CITY OF ALBUQUERQUE

Re: Lowes Pad Site, 6230 Paseo Del Norte NE,

Subject: D18/D014D: Out parcels at Lowes on SW corner of Paseo del Norte & San Pedro

RE: Los Angeles Center (Lowes' out-parcels), Tracts A-1-B-1-B & A-1-B-1-C Grading and Drainage Plan for Grading, Paving and Building Permit SW Corner of Paseo del Norte & San Pedro PE Stamp: 7/11/12 (D18-D014D)

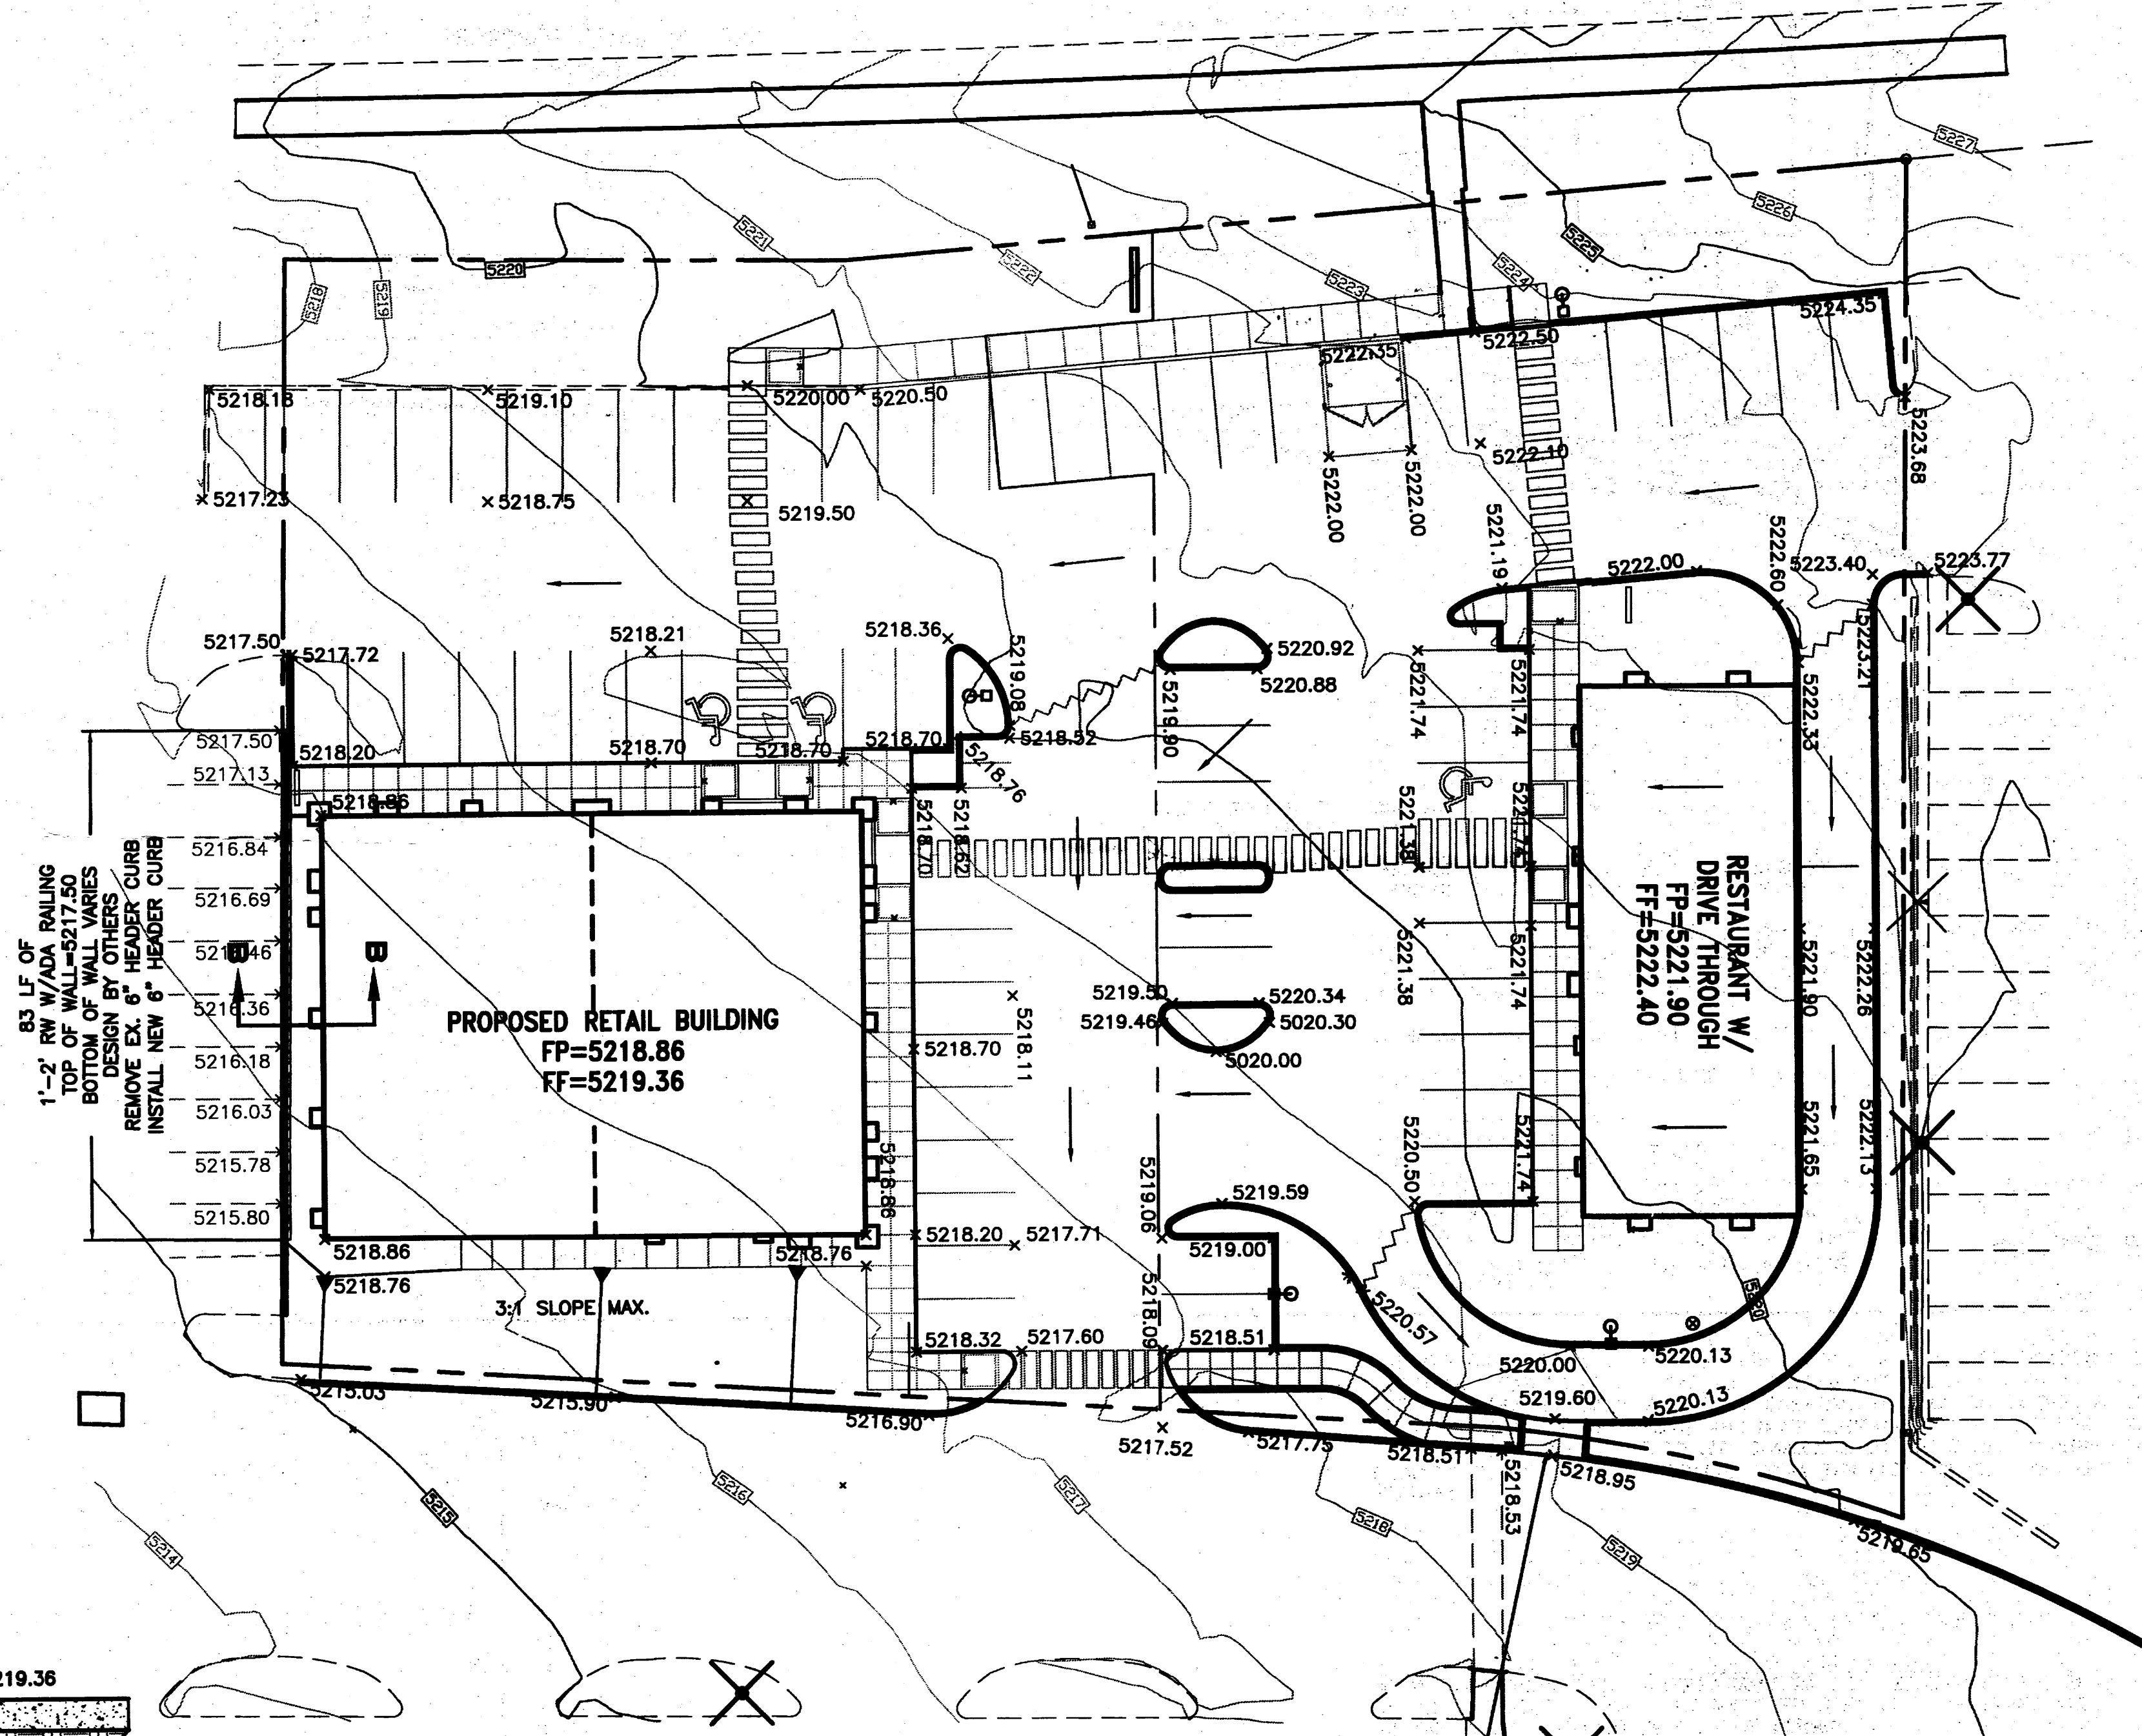
- Where does roof runoff go from SW building? Avoid erosion on the steep side slopes S & W of pad.
- 2. Per DPM, the Dumpster pad for the restaurant must drain to the Sanitary Sewer. Show this on the plan.
- ---- more of a transportation question(s) -----
- 3. At the 10' rundown south of the restaurant:
 - a. at 10' wide will it become a shortcut to the drive-though?
 - b. The original Lowes site had a N-S pedestrian corridor just west of the restaurant pad. This plan seems to carry that through the site, except at the drive-through. Will it be continuous, and will it be compatible with the drainage rundown?

- 1. Where does roof runoff go from SW building? Avoid erosion on the steep side slopes S & W of pad. added a cobble swale and place note that roof drains shall connect to coble swale on west side. south side has no roof flow but added noter for larger angular rock landscaping.
- 2. Per DPM, the Dumpster pad for the restaurant must drain to the Sanitary Sewer. Show this on the plan. -please add to both utility and grading
- ---- more of a transportation question(s) -----
- 3. At the 10' rundown south of the restaurant:
 - a. at 10' wide will it become a shortcut to the drive-though? put bollard in middle
 - b. The original Lowes site had a N-S pedestrian corridor just west of the restaurant pad. This plan seems to carry that through the site, except at the drive-through.
